## SUBMISSION 2: SUMMARY OF ADDITIONAL CONCERNS IN RELATION TO THE PROPOSED NORTHCONNEX TUNNEL

Application number - SSI 13\_6136

MOTORWAY OPERATIONS COMPLEX - SOUTHERN VENTILATION FACILITY - SECTIONS
M1-M2-5000-DR-JD-0525

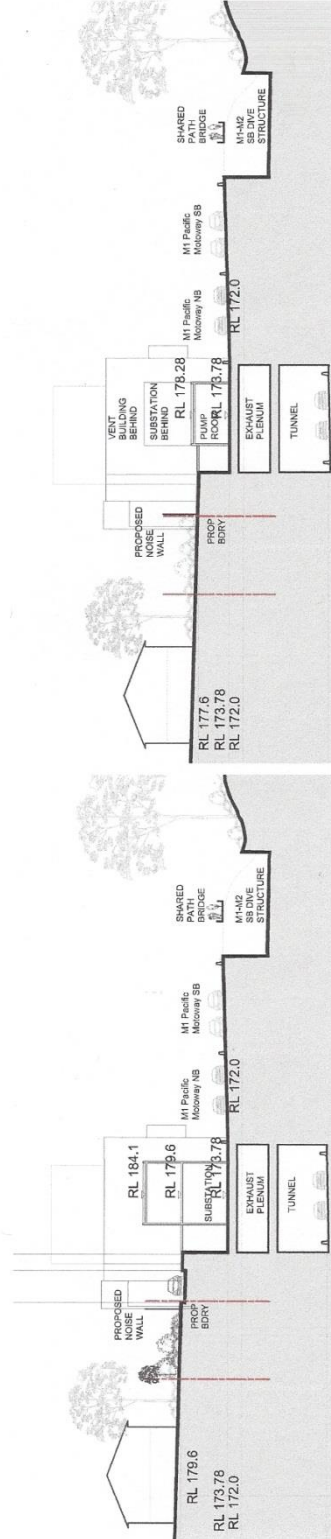
Speakers at the NorthConnex Air Quality Forum spoke of the importance of the topography in the placement of the ventilation facilities. In the NorthConnex proposal the southern ventilation facility is at the lowest point of the M2 intersection where it is surrounded on three sides by hillside cuttings. In this location the “discharge point” will barely be above the adjacent high ground.

Much is made of the intention to discharge the polluted air through the stack at 13 – 19m/s. Given that the stack is only 15m above Pennant Hills Road, a simple calculation indicates that the particles will be ejected to a height of between 23m and 33m above Pennant Hills Road. That will only be sufficient for them to be dispersed by prevailing winds IF there is wind and it is strong enough. For instance, the weather history graph showing the wind speed and direction at West Pennant Hills measured on the 24th August 2014 indicated that there was no wind until 9am and what wind there was, came from the west. Wind speeds of less than 2m/sec (ie about 8km/hour) are not considered sufficient to disperse pollution from the stack. Only a very few gusts on this day were in excess of 8km/hour.

That the Government ensures that the southbound ventilation facility ie the Stack, be located at the south-west corner, on the RMS owned land, at the edge of the Pennant Hills Golf course. In this location, the southbound tunnel can be efficiently, effectively and economically ventilated.

The impact of the stack plumes on the surrounding residential areas must be modelled using its current proposed position and height and also modelled with the stack positioned on the golf course side of Pennant Hills Road, where it is topographically higher. This would allow an objective, impartial, scientifically based assessment to be made of the most effective location for the stack.
